WEST SUSSEX COUNTY COUNCIL CONSULTATION

TO:	Arun District Council FAO: Simon Davis
FROM:	WSCC - Highways Authority
DATE:	3 February 2022
LOCATION:	Land adjacent to Bonhams & Flints, Hoe Lane, Flansham, PO22 8NP
SUBJECT:	Y/7/22/PL Erection of 4 No dwelling with access from Hoe Lane and associated landscaping, including native orchards and wildflower meadows. This application is a Departure from the Development Plan and is in CIL zone 3 and is CIL Liable as new dwellings.
DATE OF SITE VISIT:	N/A
RECOMMENDATION:	Advice
S106 CONTRIBUTION TOTAL:	N/A

Client			
Mr V. Coulin			
Project			
Bonhams, Flansham, Felpham			
Drawing title			
Fire Tender Sweep Path Analysis			
Drawing No.			Rev.
2021/6302/002			P1
Scale	Drawn by	Checked by	
1:250	GE	CB	AJ

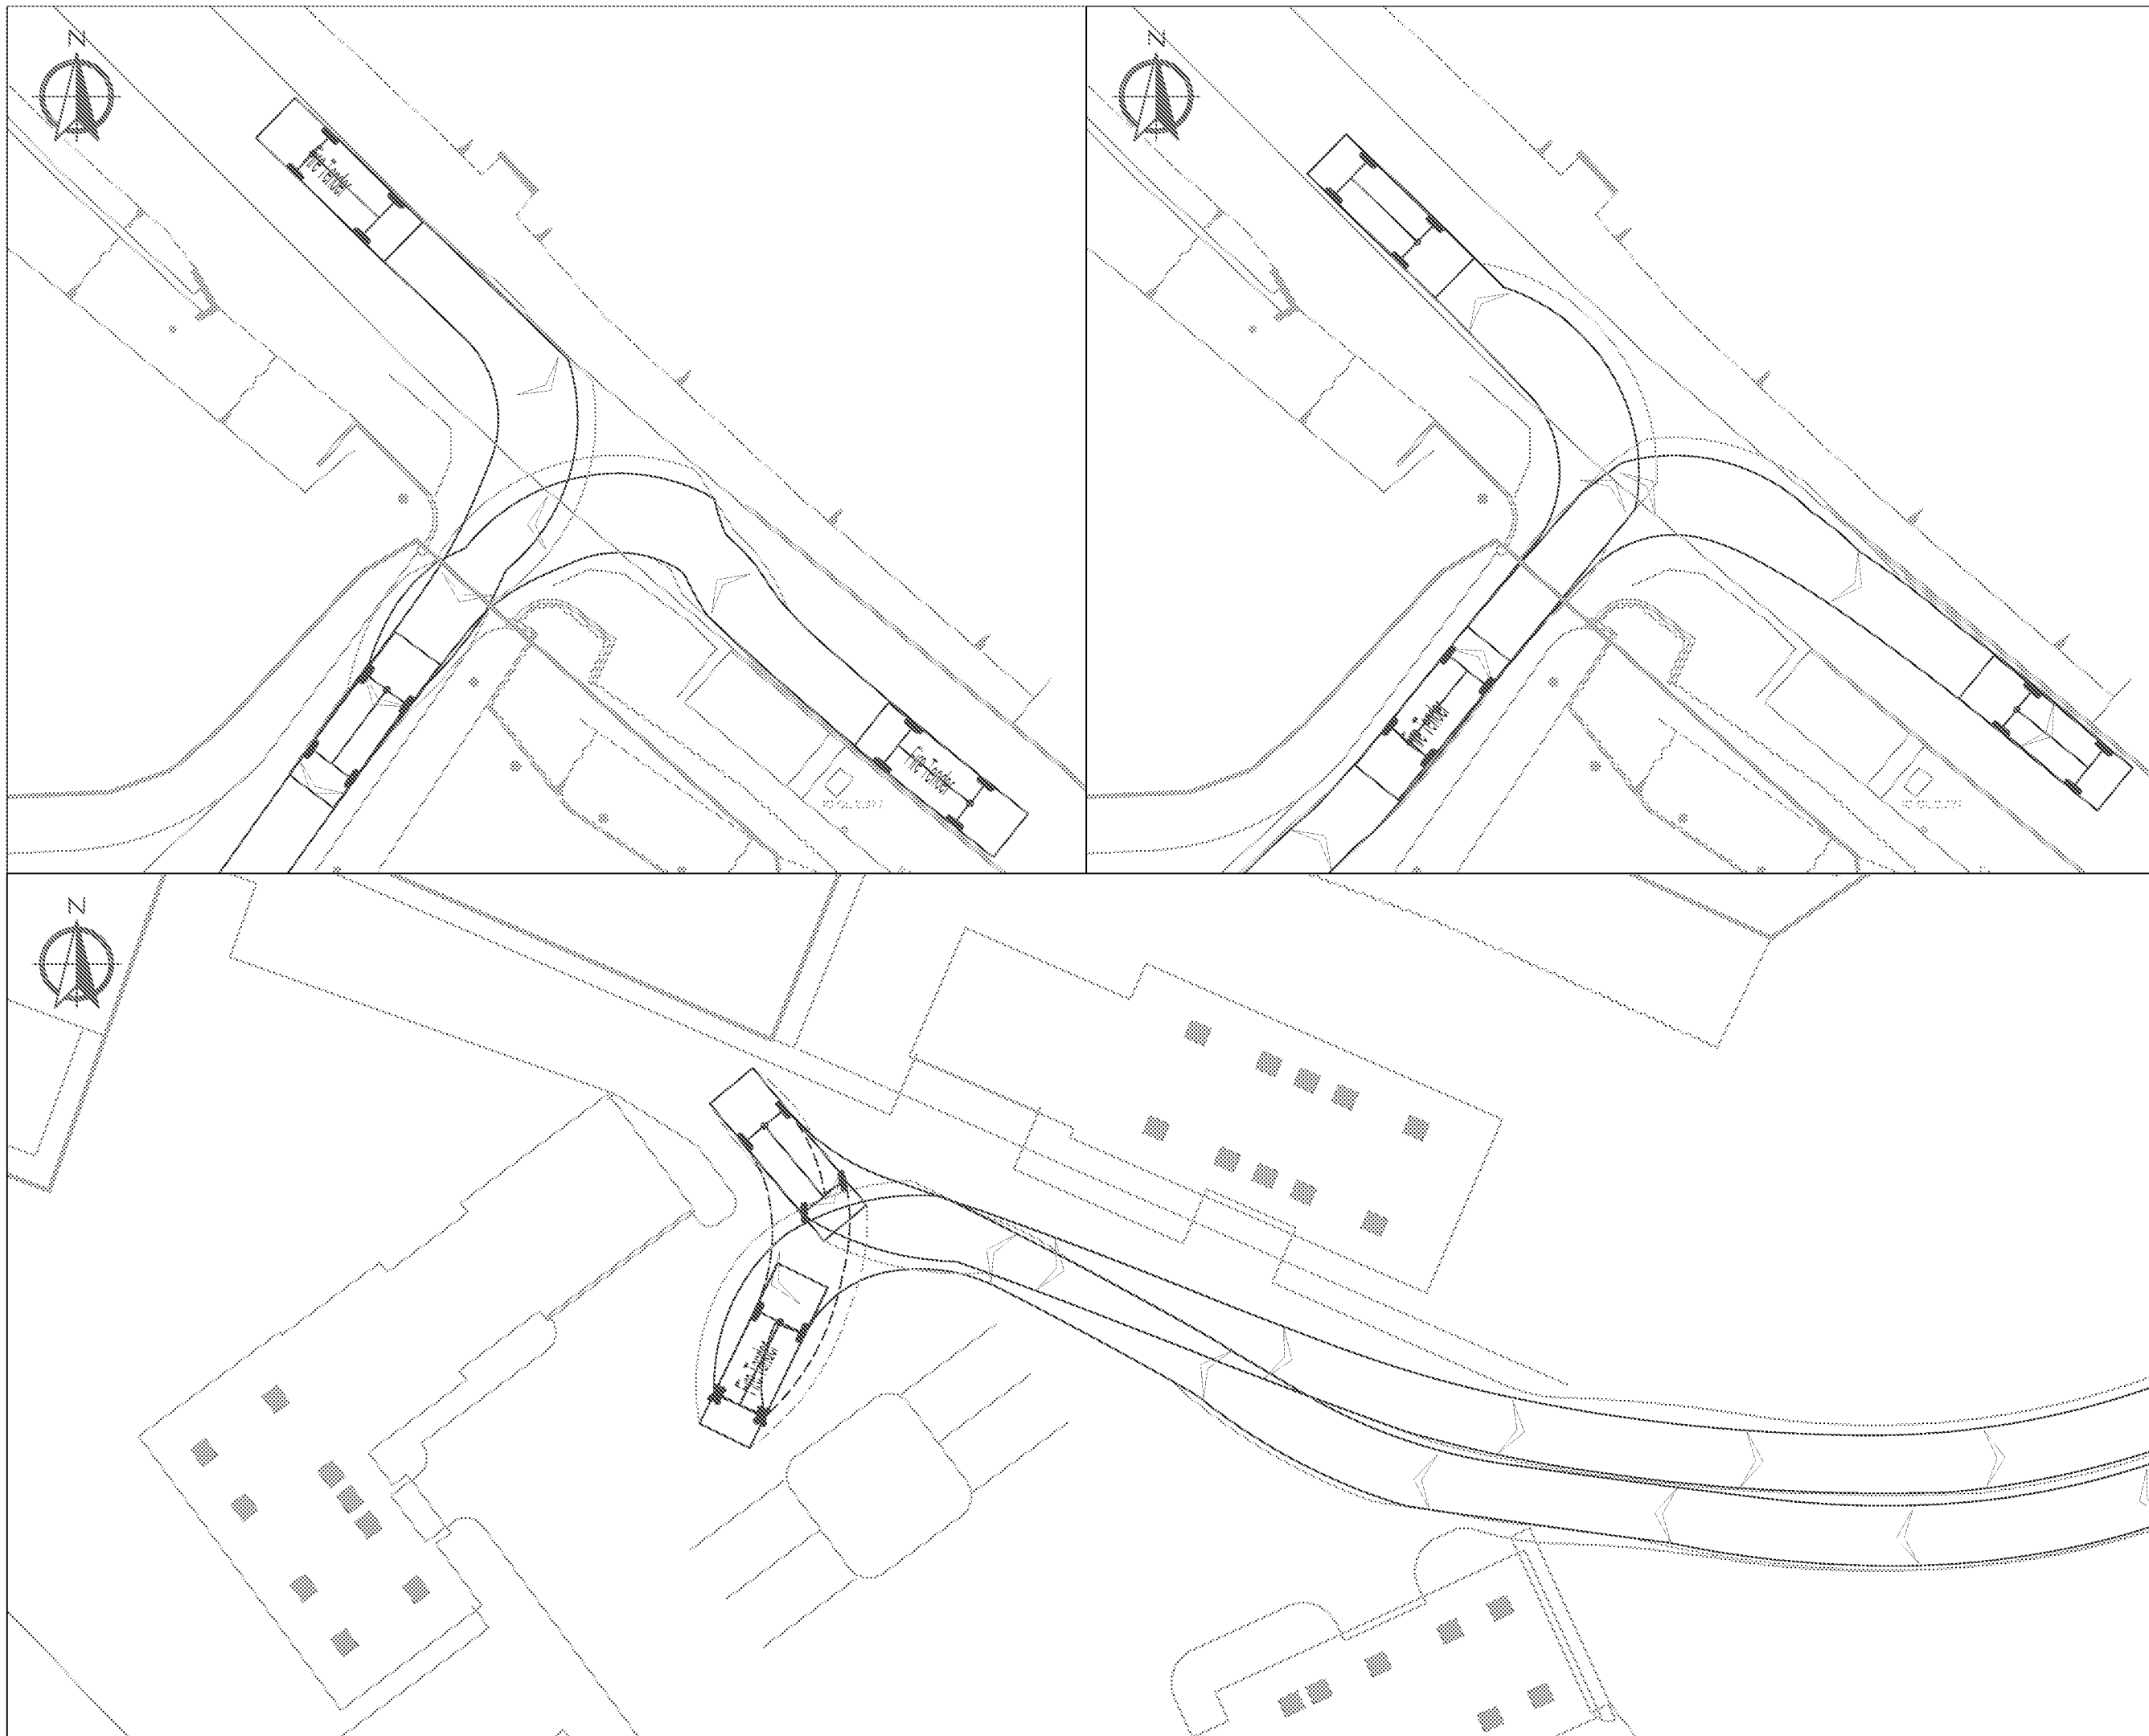
Regarding on-site turning, the applicant has demonstrated on-site turning for both a fire appliance and refuse vehicle via swept path tracking, to the satisfaction of the LHA.

Client				
Mr V. Coulin				
Project				
Bonhams, Hantsham. Felpham				
Drawing No.				
Refuse Vehicle Sweep Path Analysis				
Drawing No.				Rev.
2021/6302/004				P1
Issue	1.050	Drawn by	Checked and by	As
		GE	CB

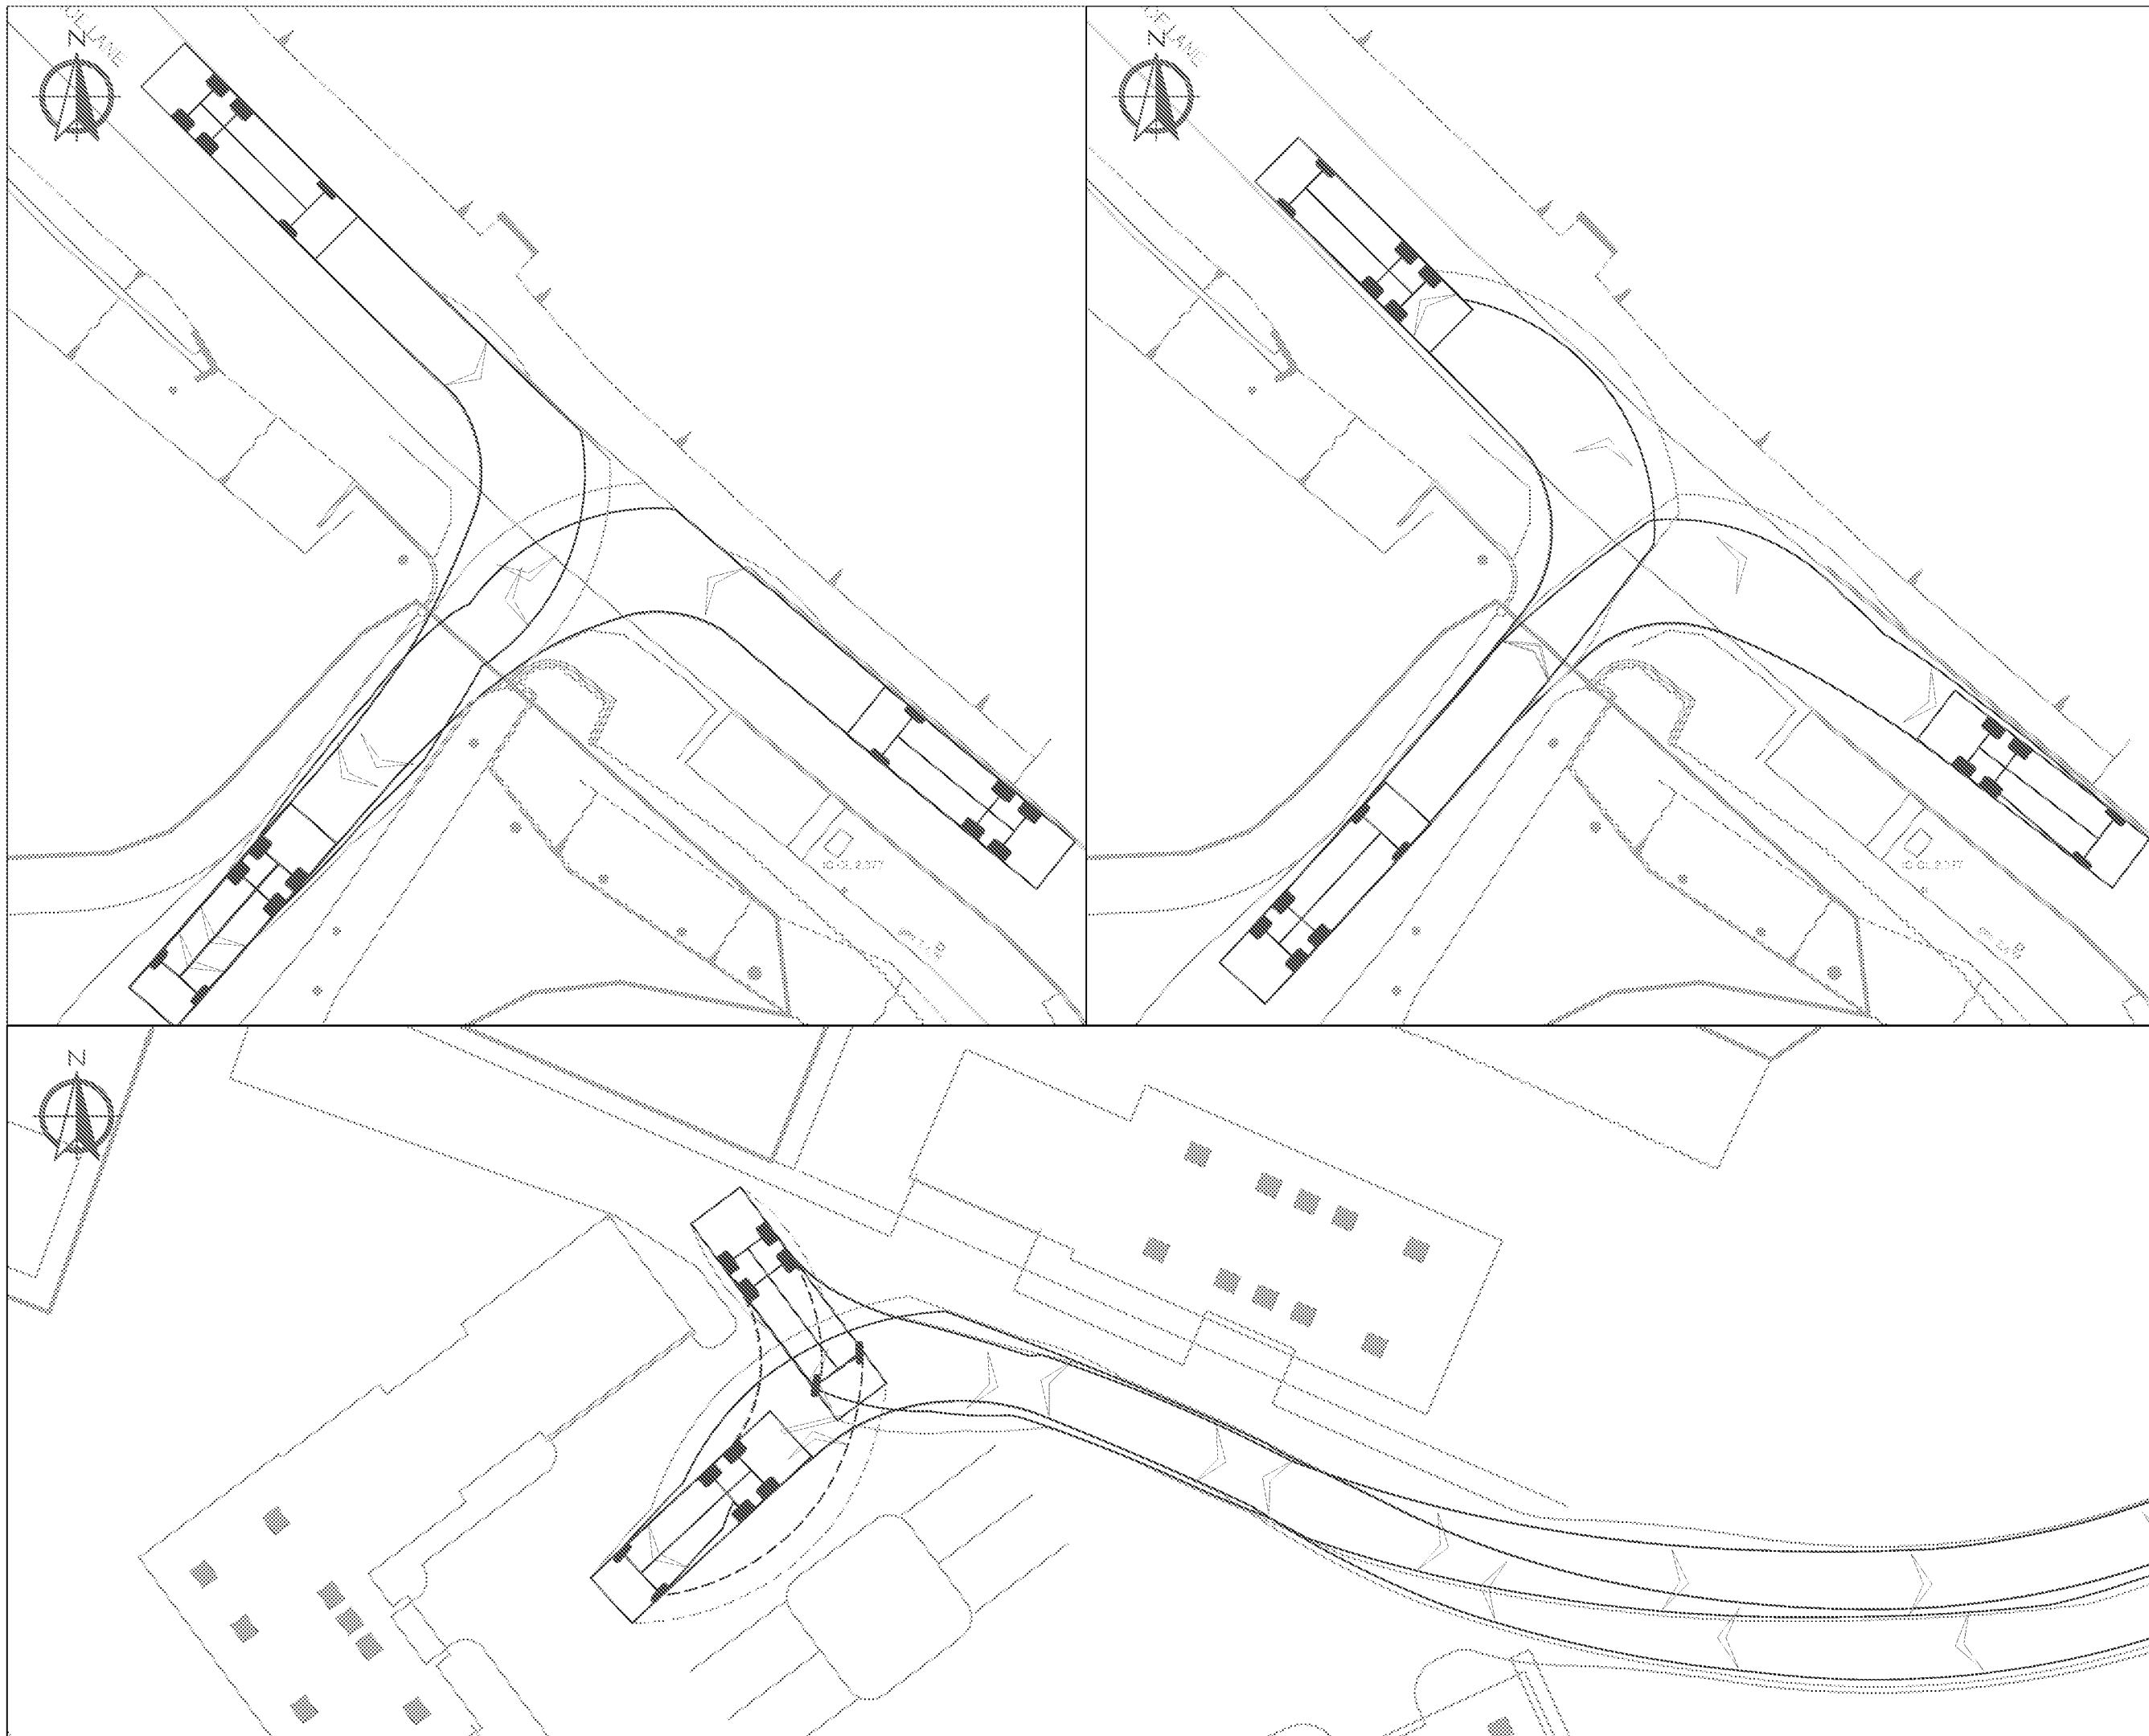
The applicant proposes to utilise the existing vehicular access on Hoe Lane for this development. The Transport Statement states that the proposals include a potential widening of the existing access by 1m. There would be a benefit to implementing this, as this would improve visibility and allow for better manoeuvrability for service vehicles accessing the development.

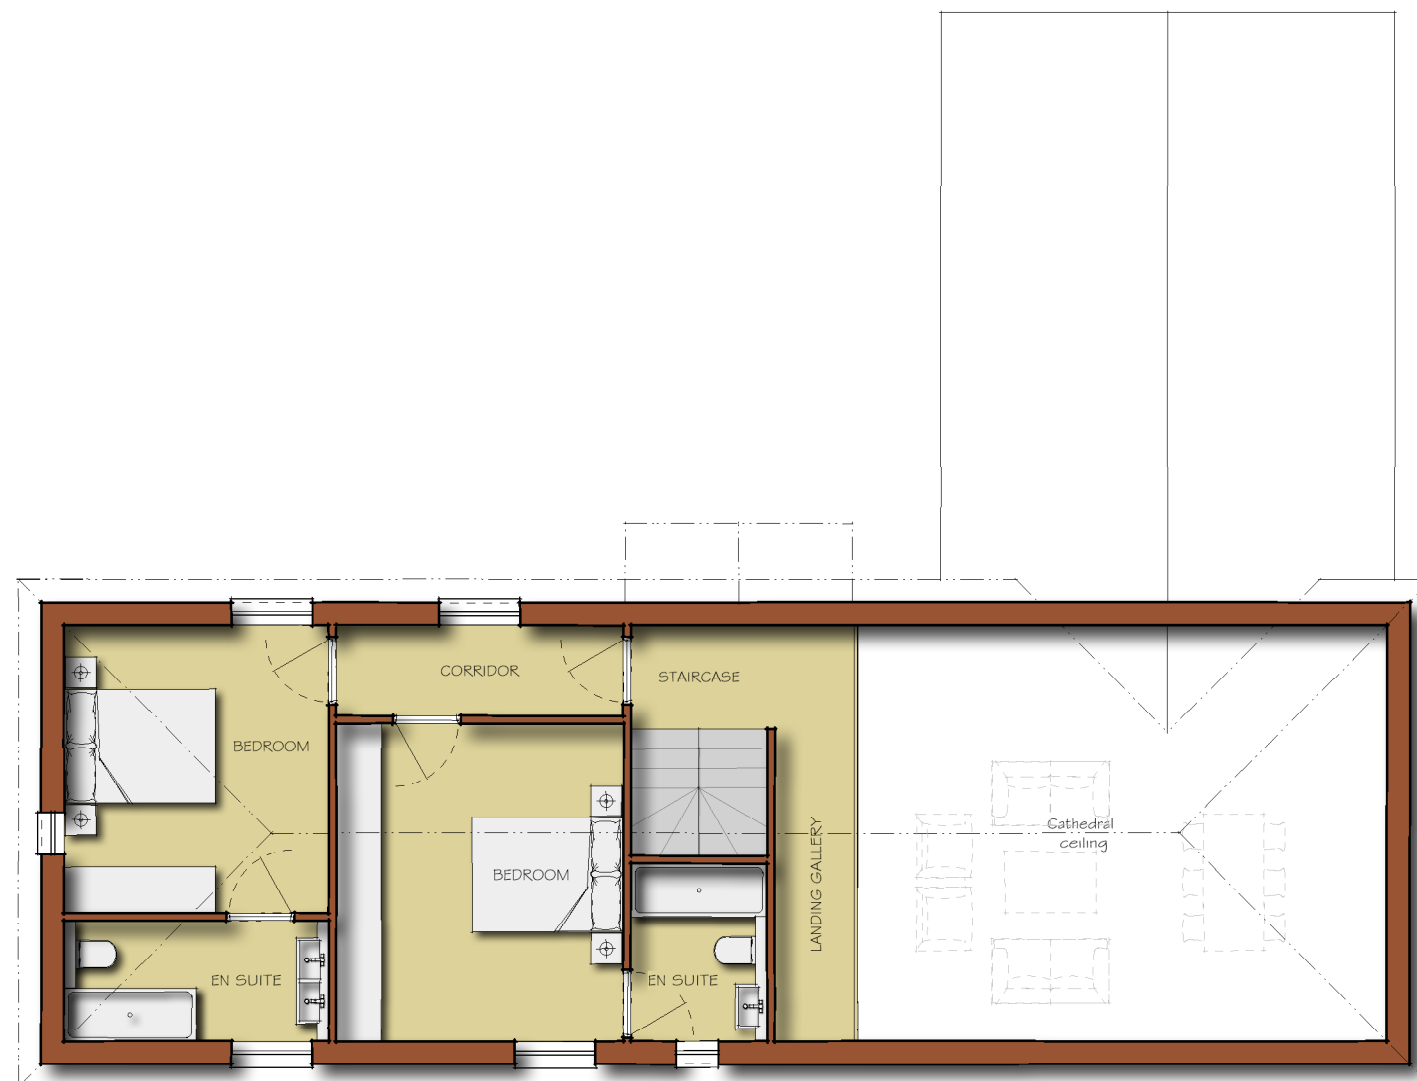
However, from inspection of the plans, the proposed garages do not meet the minimum specifications to be considered for parking provision. The applicant is requested to enlarge the garages to meet the minimum internal dimensions for double-bay garages of 6m x 6m as set out in Manual for Streets (MfS). It should be noted that the applicant intends to utilise the garages for cycle parking; the applicant should enlarge the garages to MfS specifications to be considered for cycle parking provision also.
